**OXFORDSHIRE COUNTY COUNCIL’S RESPONSE TO CONSULTATION
ON THE FOLLOWING DEVELOPMENT PROPOSAL**

Application no: 23/00390/F

Proposal: The erection of an industrial Rubb storage building, extension of the existing industrial building to create a new visitor reception, external alterations to elevations, reconfiguration of the existing open service yard and car park, provision of photovoltaic (PV) panels on roof and associated landscaping and works

Location: E P Barrus Ltd, E P Barrus Ltd, Launton Road, Bicester, OX26 4UR

Barrus, Bicester Date: **12.09.2022**
 Scale: **1:500@A3**
 Status: **Preliminary**
Site Masterplan Drawn: **JC**
220025 - A - PR - 100 Revision: **C**

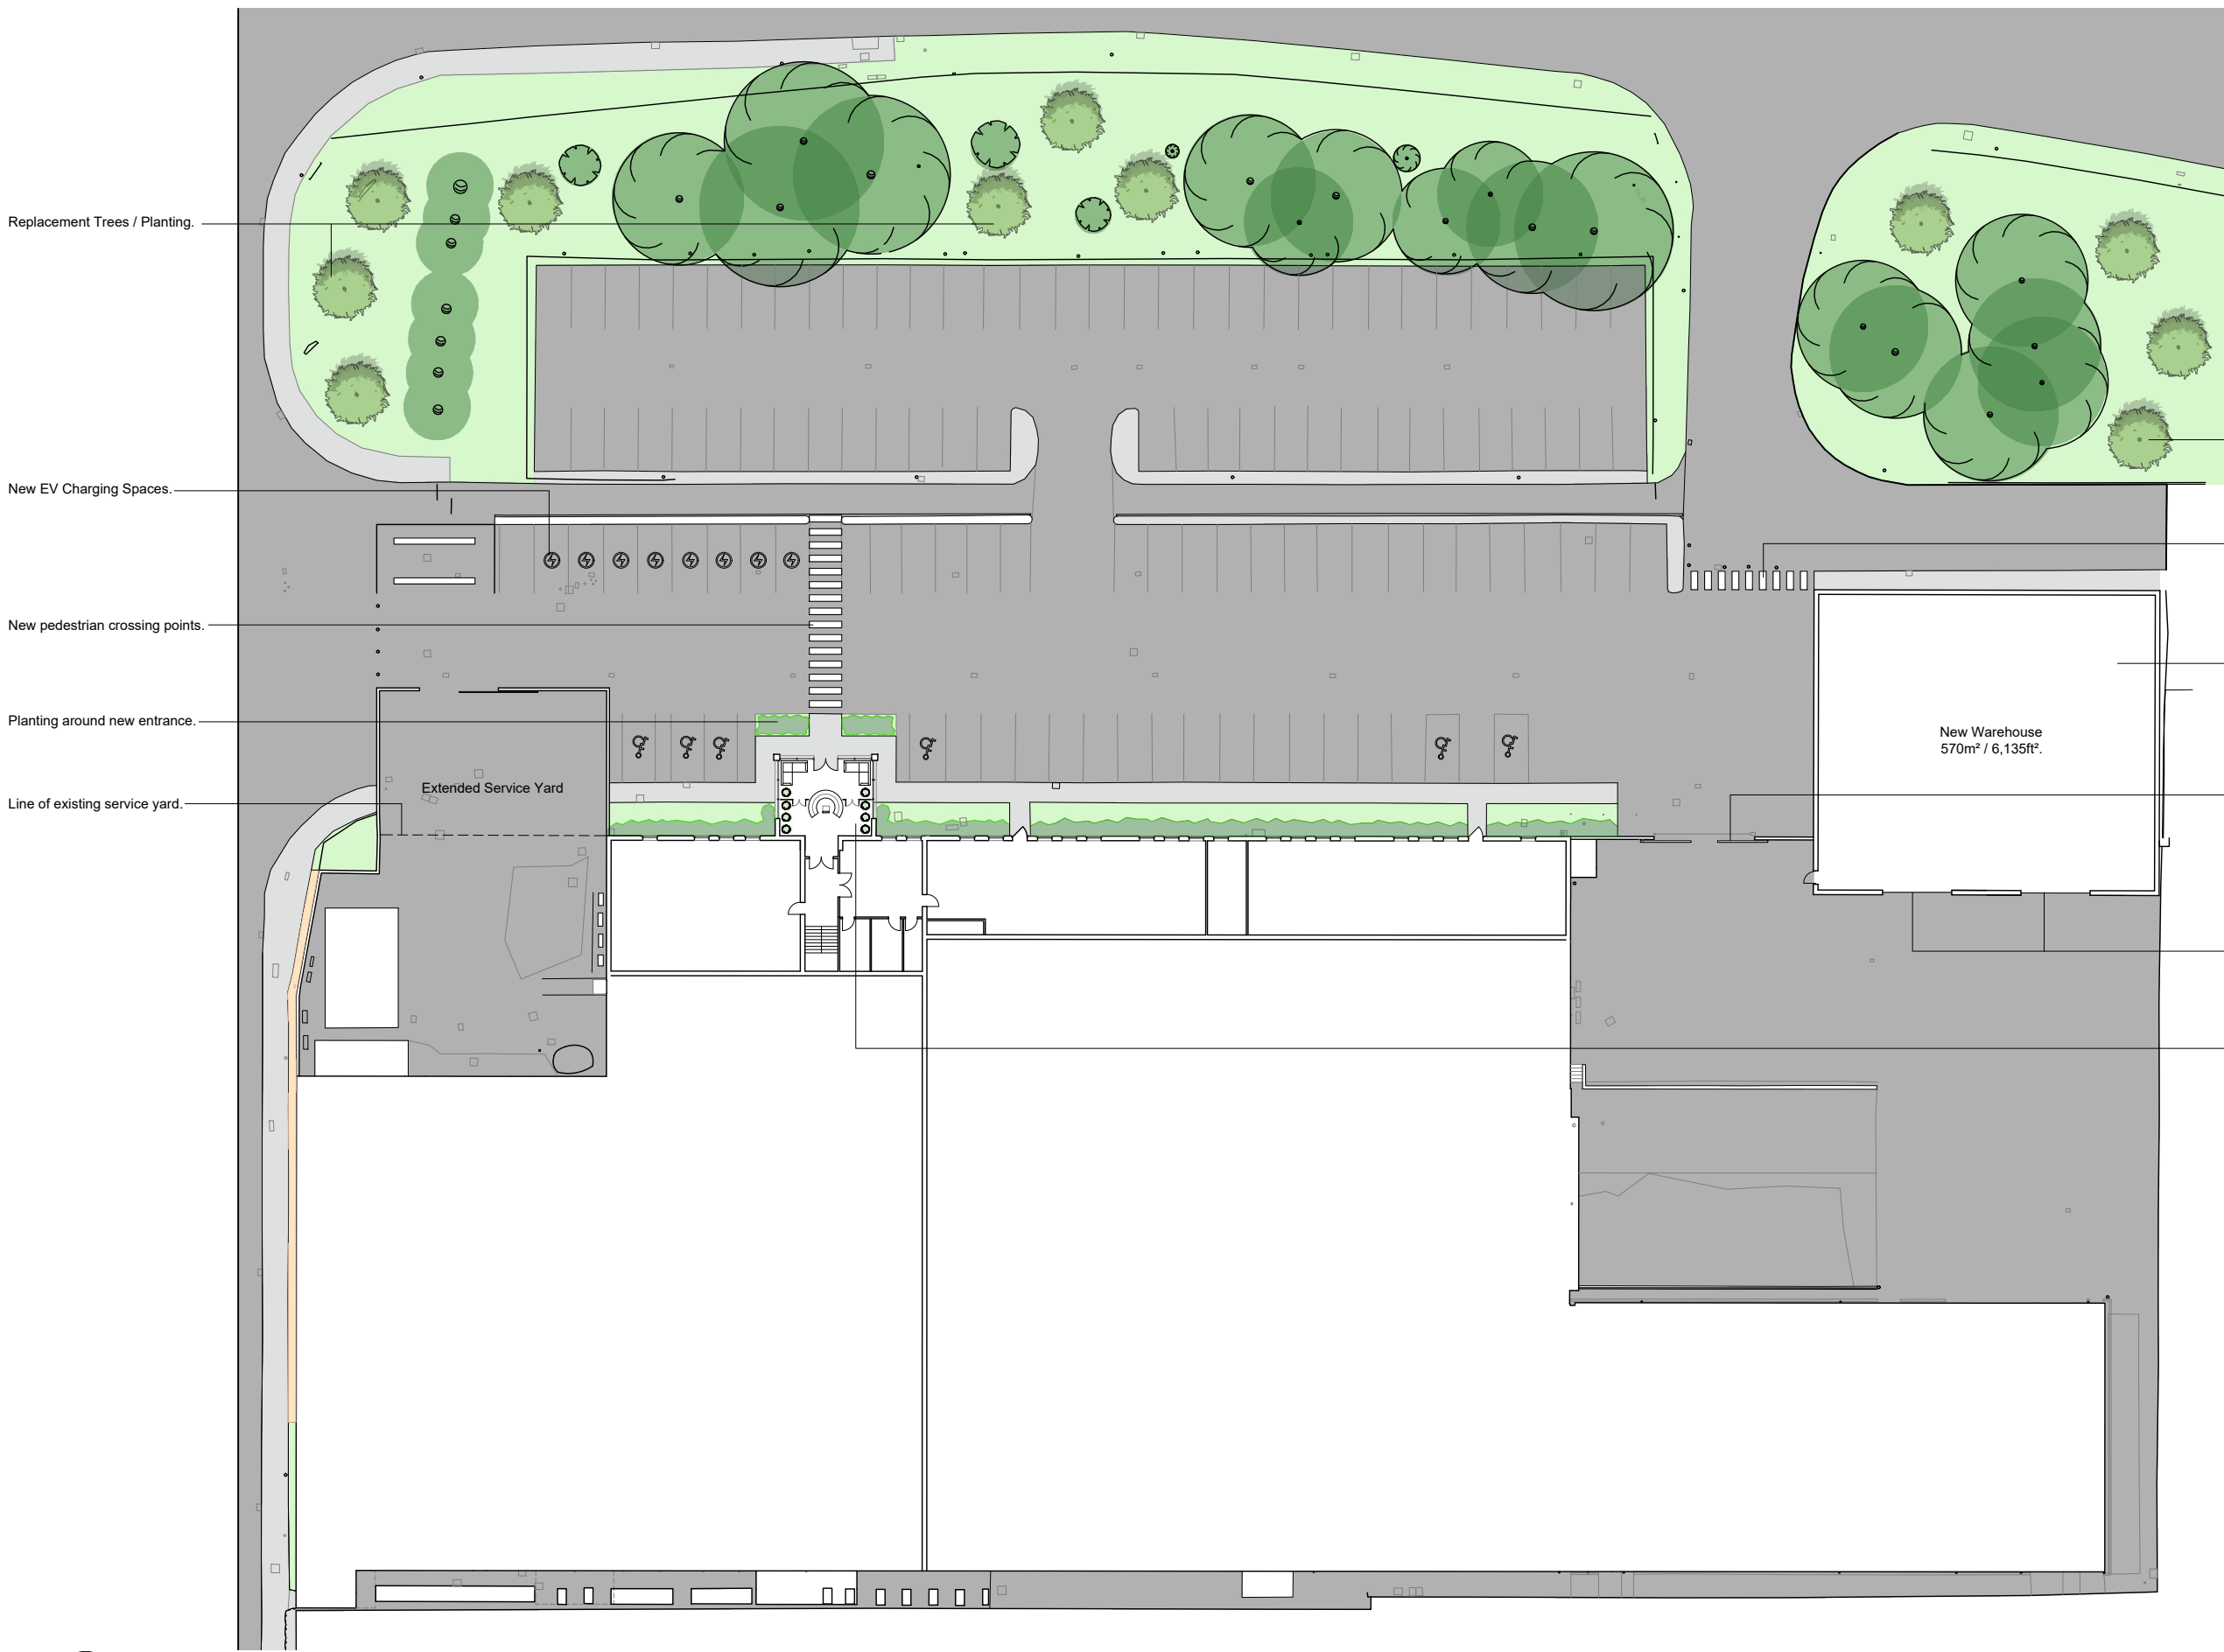
The proposed pedestrian crossing point will require a section 278 agreement between the applicant and OCC. A Traffic Regulation Order (TRO) amendment will also be required. The local Councillor will need to be pre-consulted for their comments on the TRO amendment before it is granted.

New pedestrian crossing along western perimeter of the site

An amendment to the existing TRO
